KIRKLEES METROPOLITAN COUNCIL INVESTMENT & REGENERATION SERVICE

DELEGATED DECISION TO DETERMINE APPLICATIONS FOR LISTED BUILDING CONSENT

Reference No:	2024/44/91961/W
Site Address:	749, New Hey Road, Outlane, Huddersfield, HD3 3YL
Description:	Discharge of details reserved by conditions 4-9 and 11 on previous permission 2023/91174 for Listed Building Consent for the conversion and adaption of an existing Listed barn to form a new dwelling with associated car parking and external works [Listed Building]
Recommending Officer:	Sebastian Pickles

2024/91961 - Officer Report

TIMBER WINDOWS JOINERY DETAILS - SECTION B

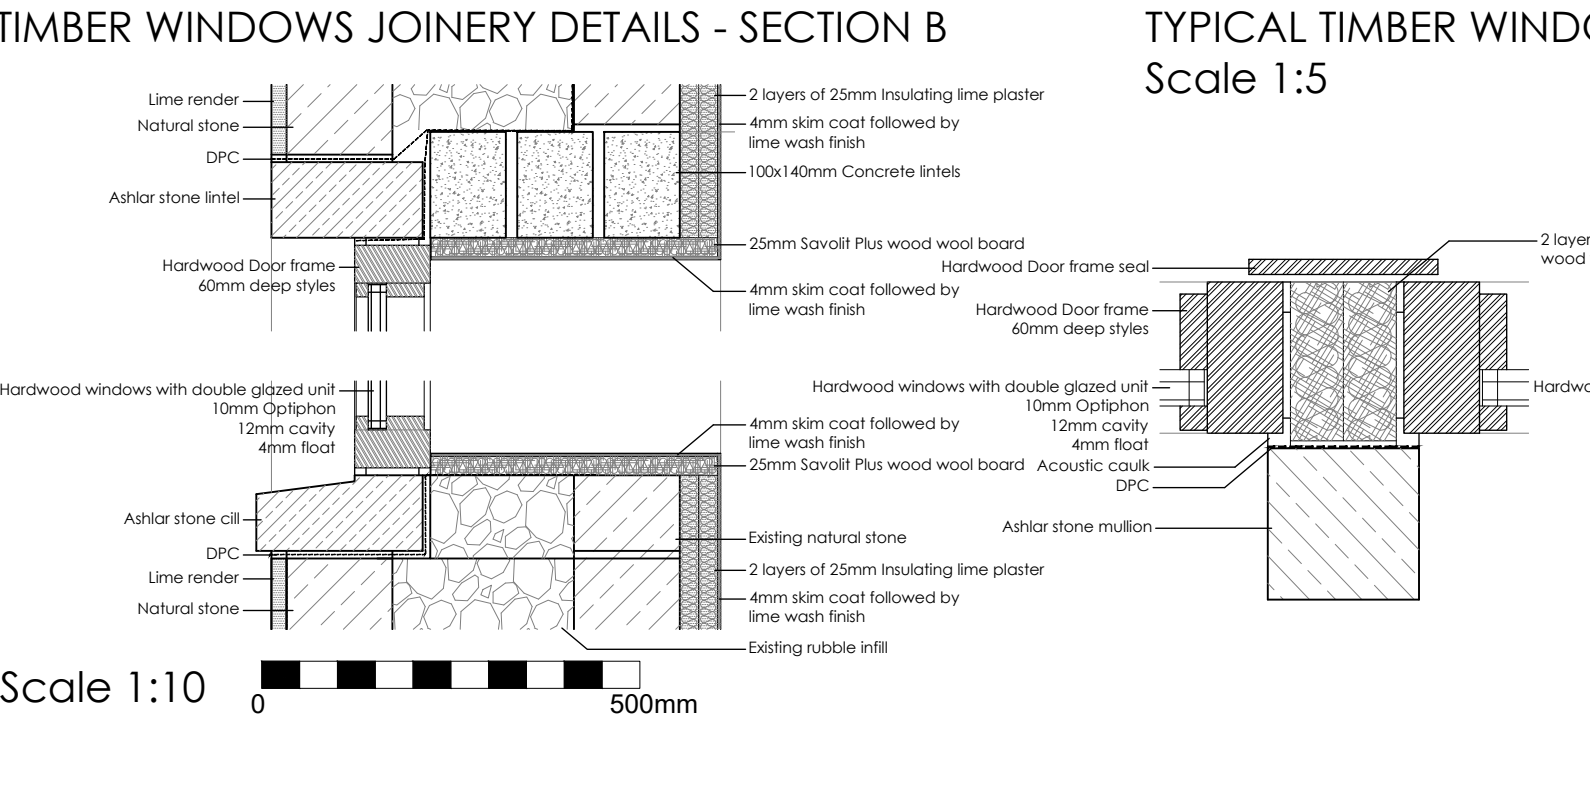
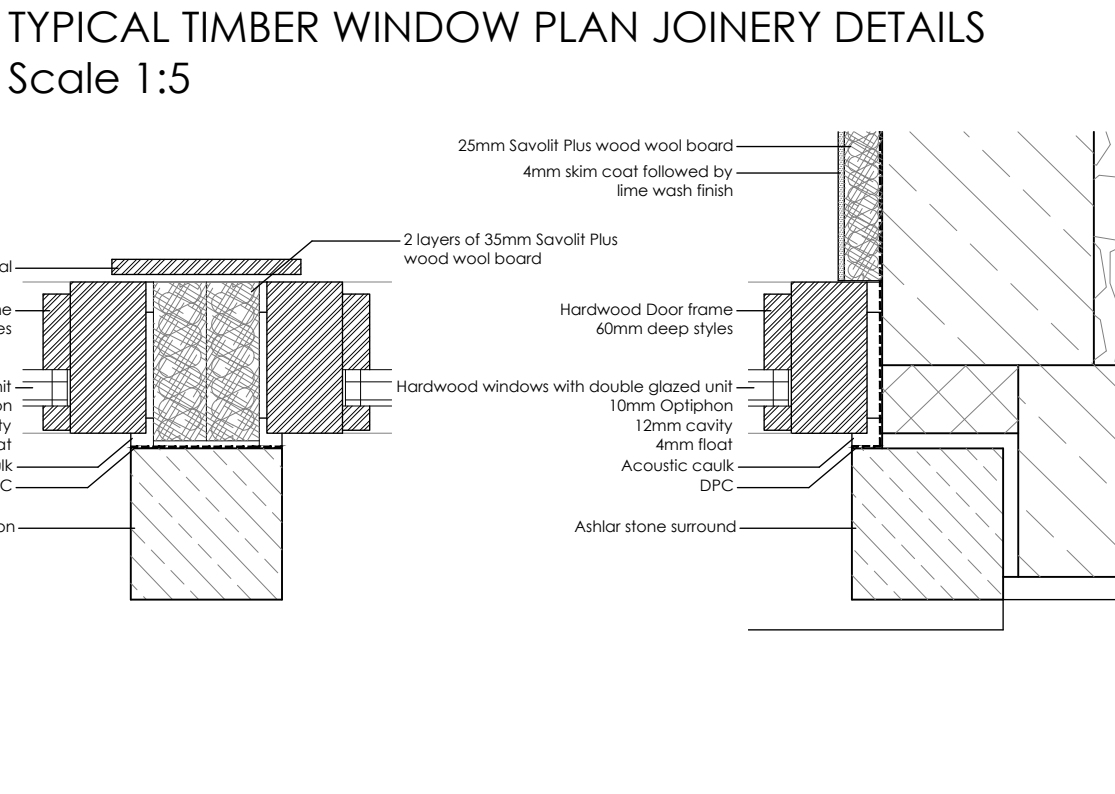
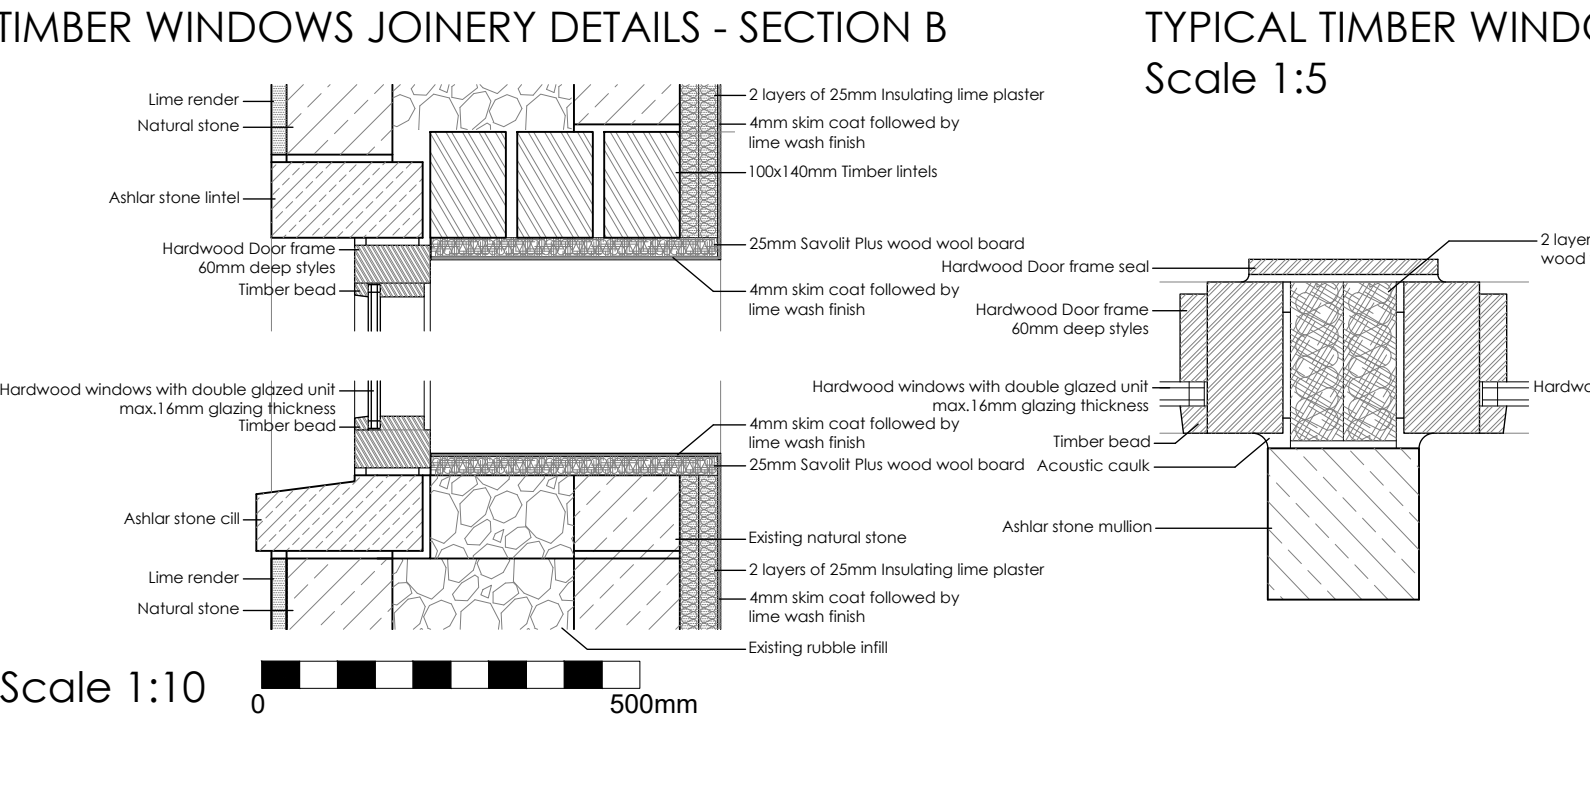
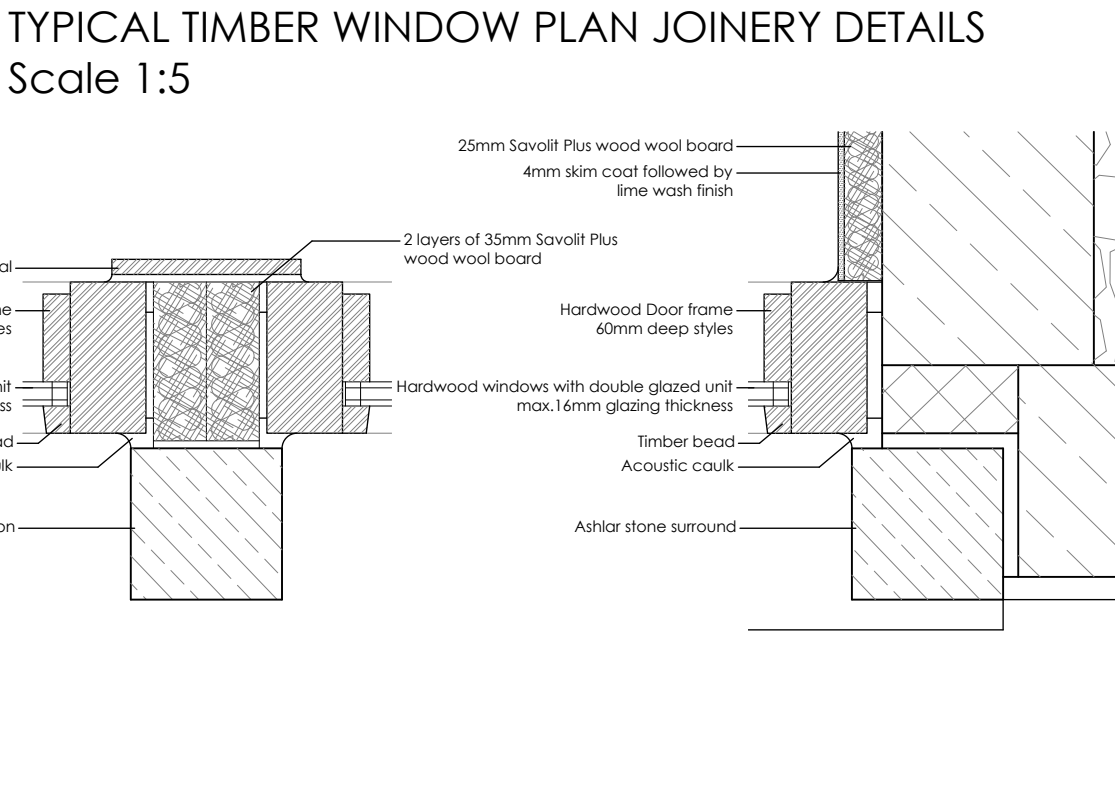
The details for conditions 4 to 9 and 11 have been provided on a detailed construction plan. Upon initial assessment of the submitted details, some of the details submitted were considered inappropriate. These were the thickness of the proposed double-glazing units, the beading detail for the windows, the proposed use of concrete lintels for the building and the use of DPCs within the repair and conversion of the building.

Following engagement with the applicant's agent, revised details were submitted, with revised thicknesses of the double-glazing units to 16mm. The beading detail has been refined to better reflect the angle of a putty finish. The concrete lintels have been amended to be replaced with timber lintels. The DPCs have also now been removed.
